## ADDENDUM 01

Date: February 21, 2017

Regarding: **191 Marginal Way Retail Center** – Portland, Maine

Subject: **Addendum 01**

DRAWING NUMBER
A8.10

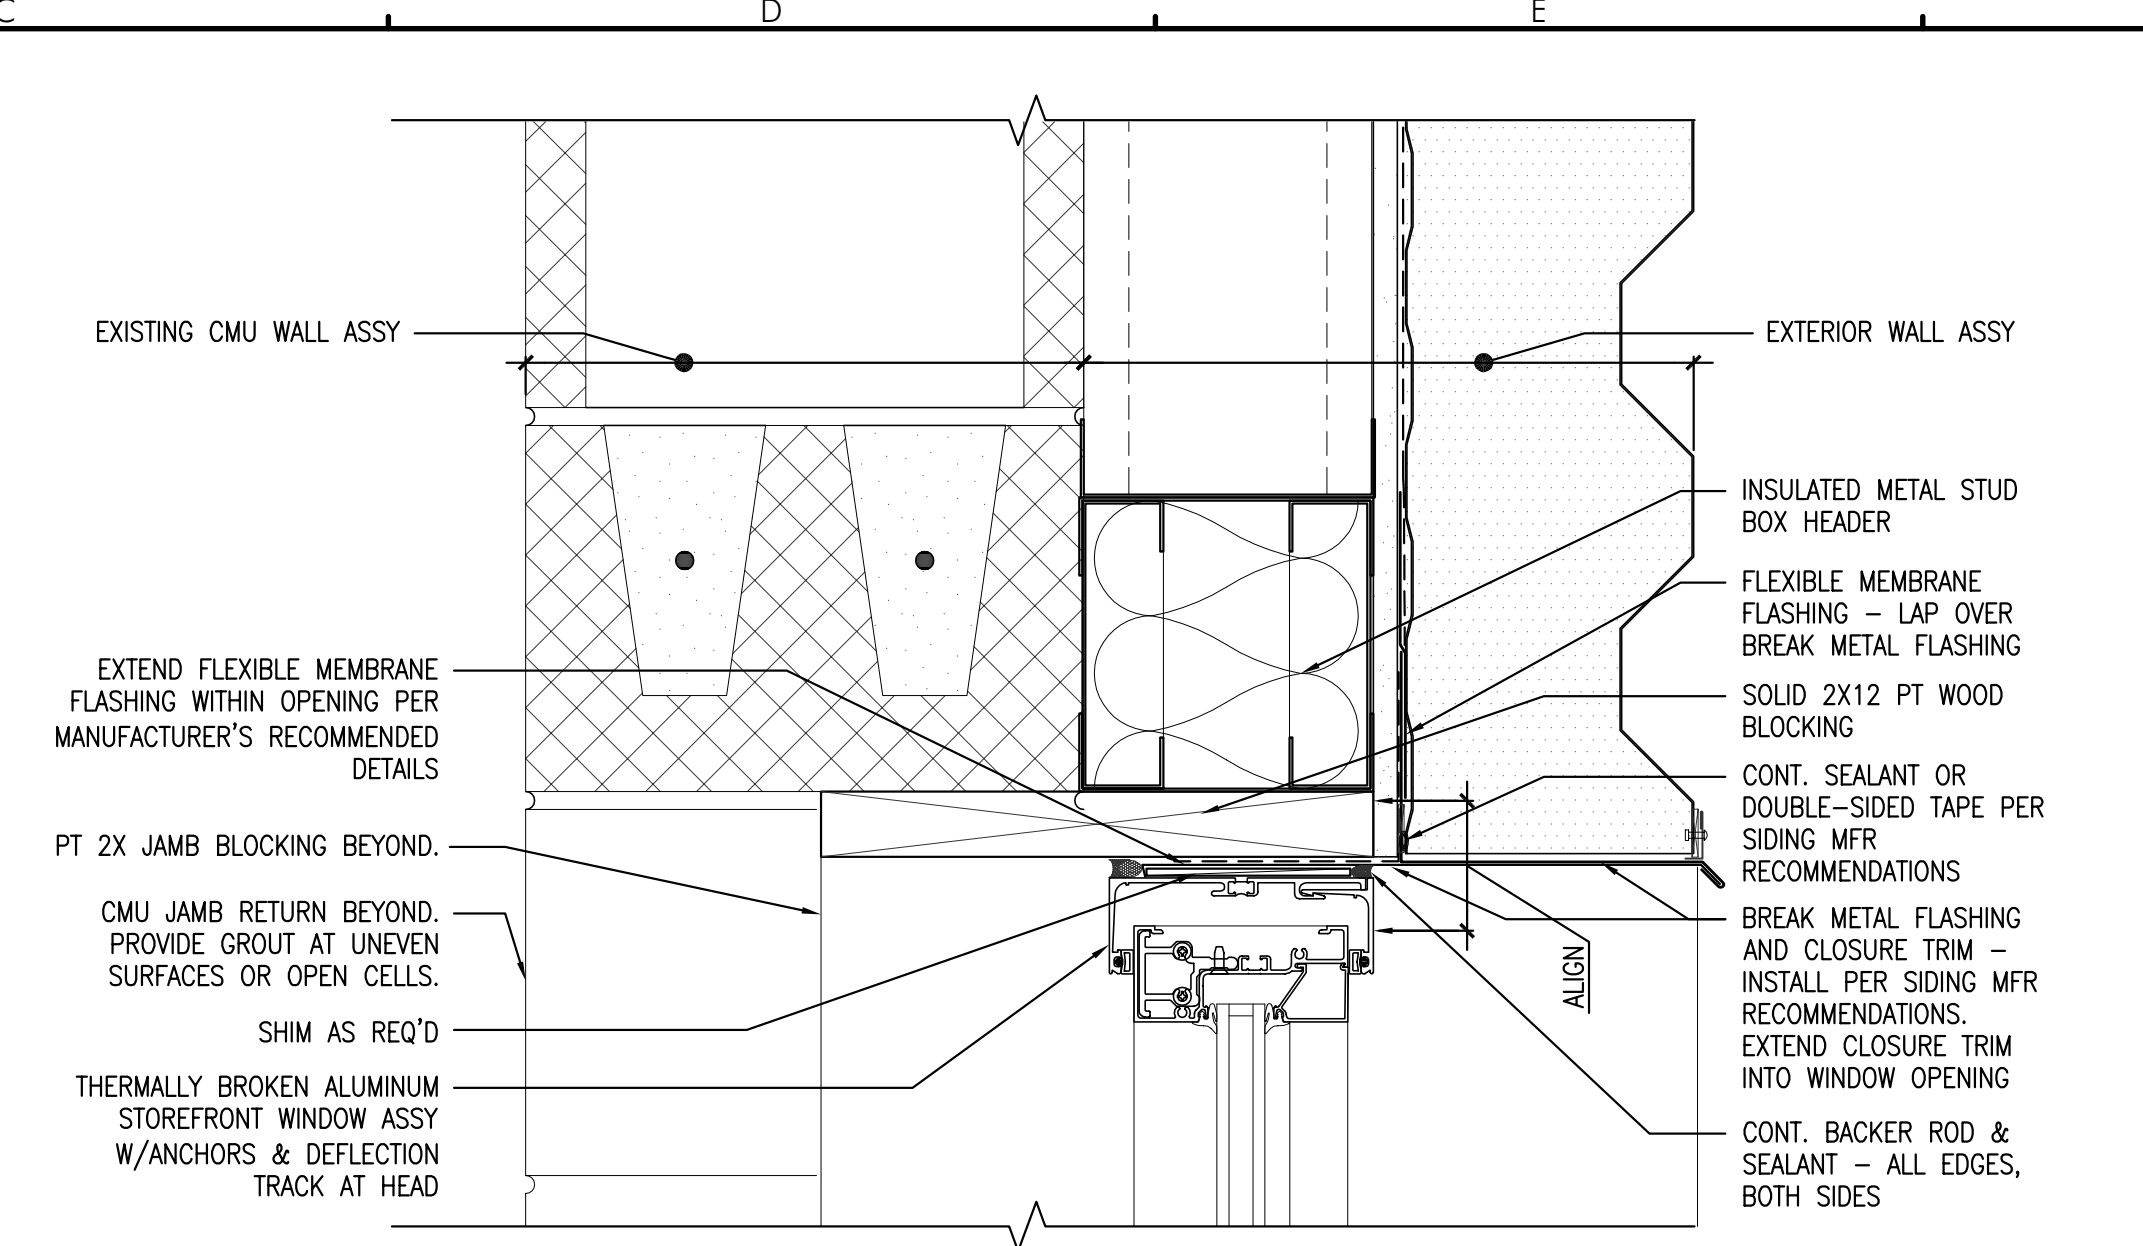
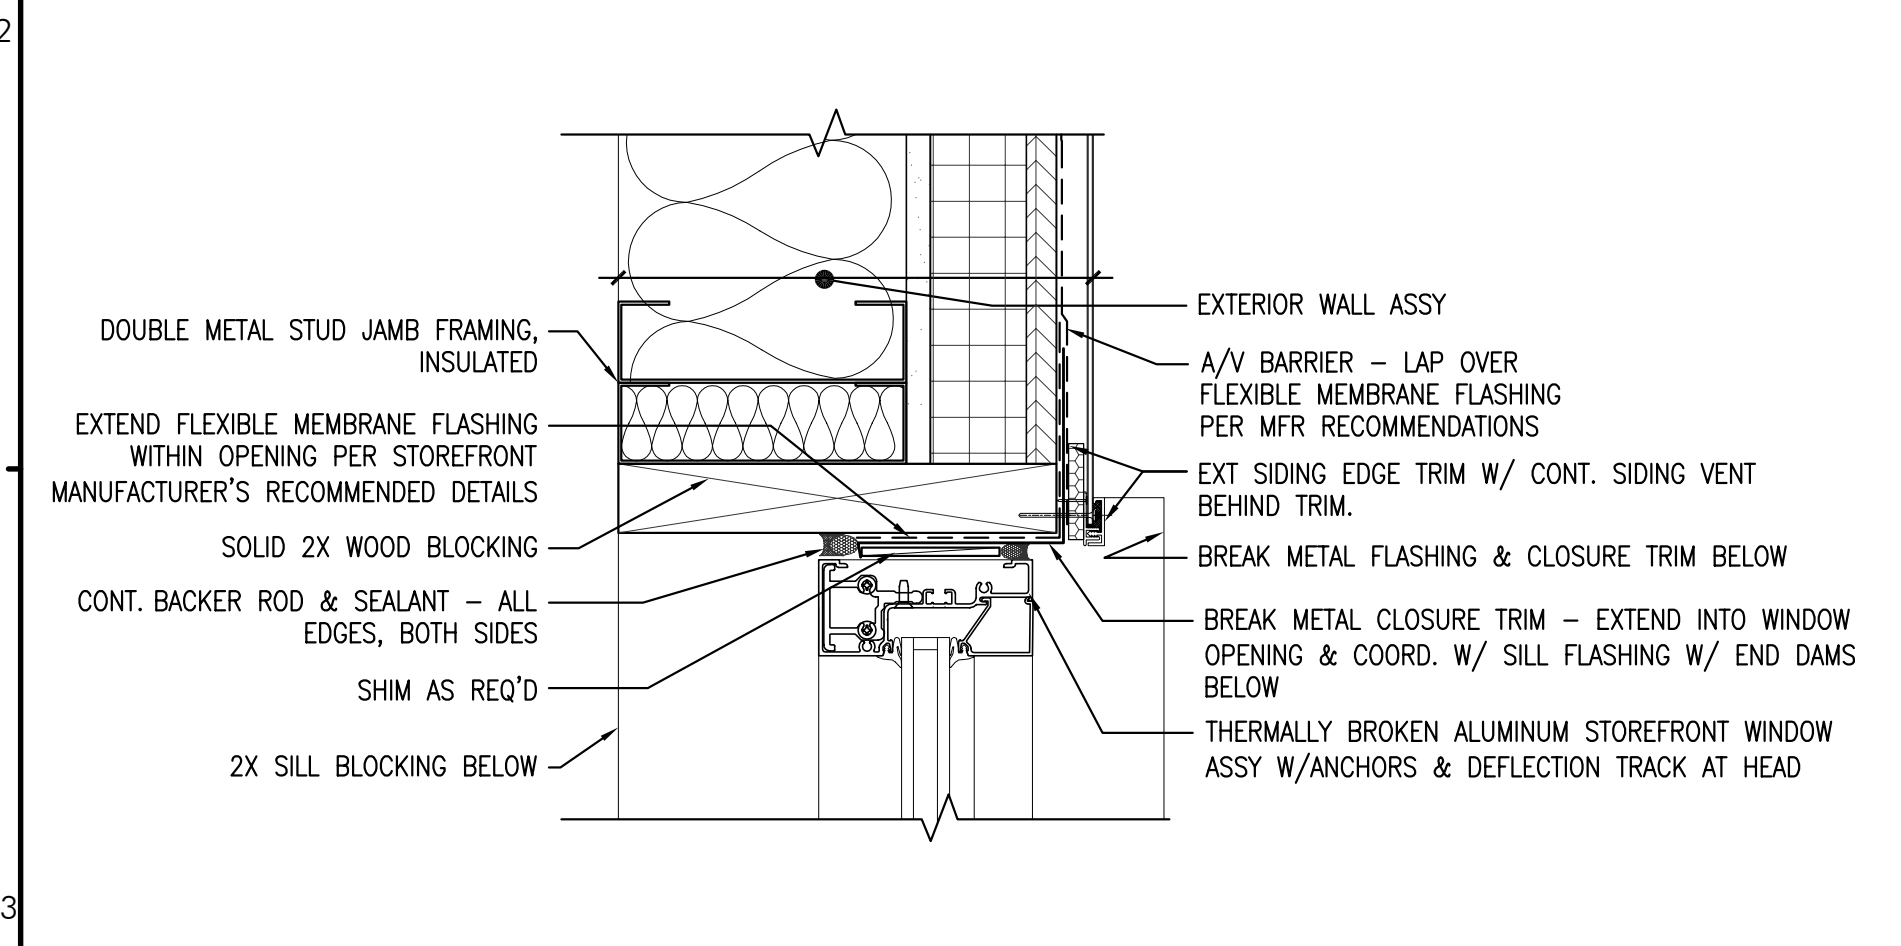
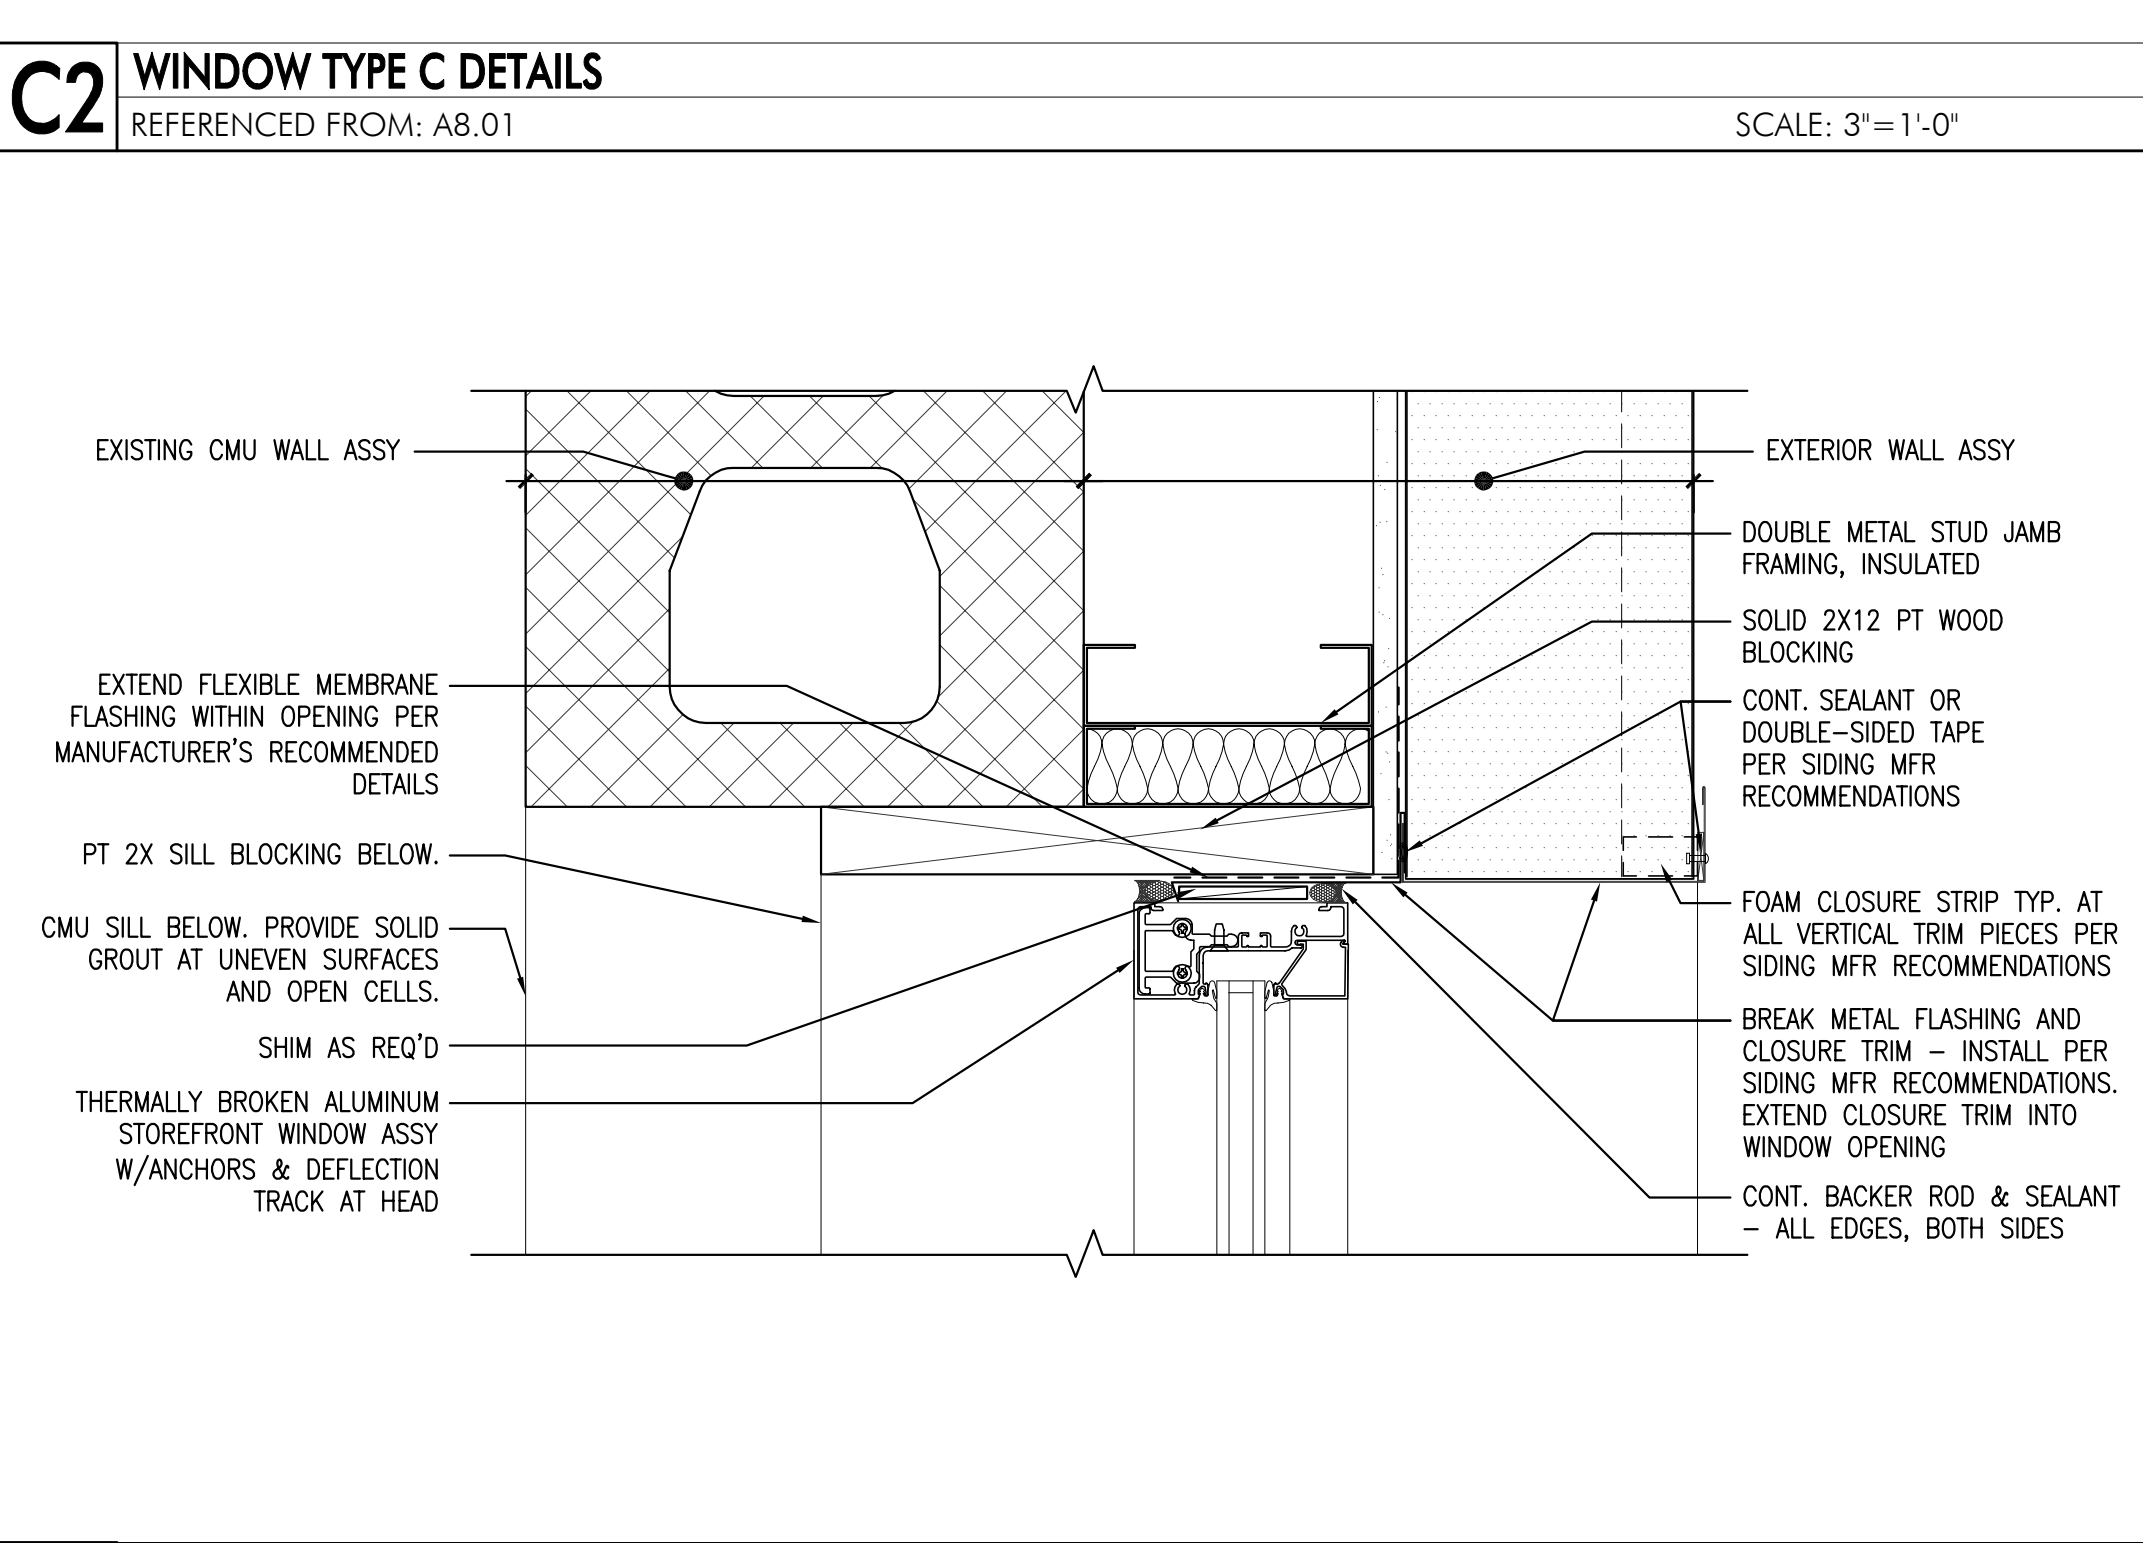
10. Sheet A6.11 – Drawings A5 and F5, delete callout for detail A4/A7.11. Refer to revised sheets A8.01 and A8.02 for door threshold detail callouts.
11. Replace sheets A8.01 and A8.02 with attached sheets, revised February 21, 2017. (Revised drawings now include detail callouts for window, storefront, and door details, on sheets A8.02 and A8.10)
12. Add A8.10 WINDOW AND STOREFRONT DETAILS to set.
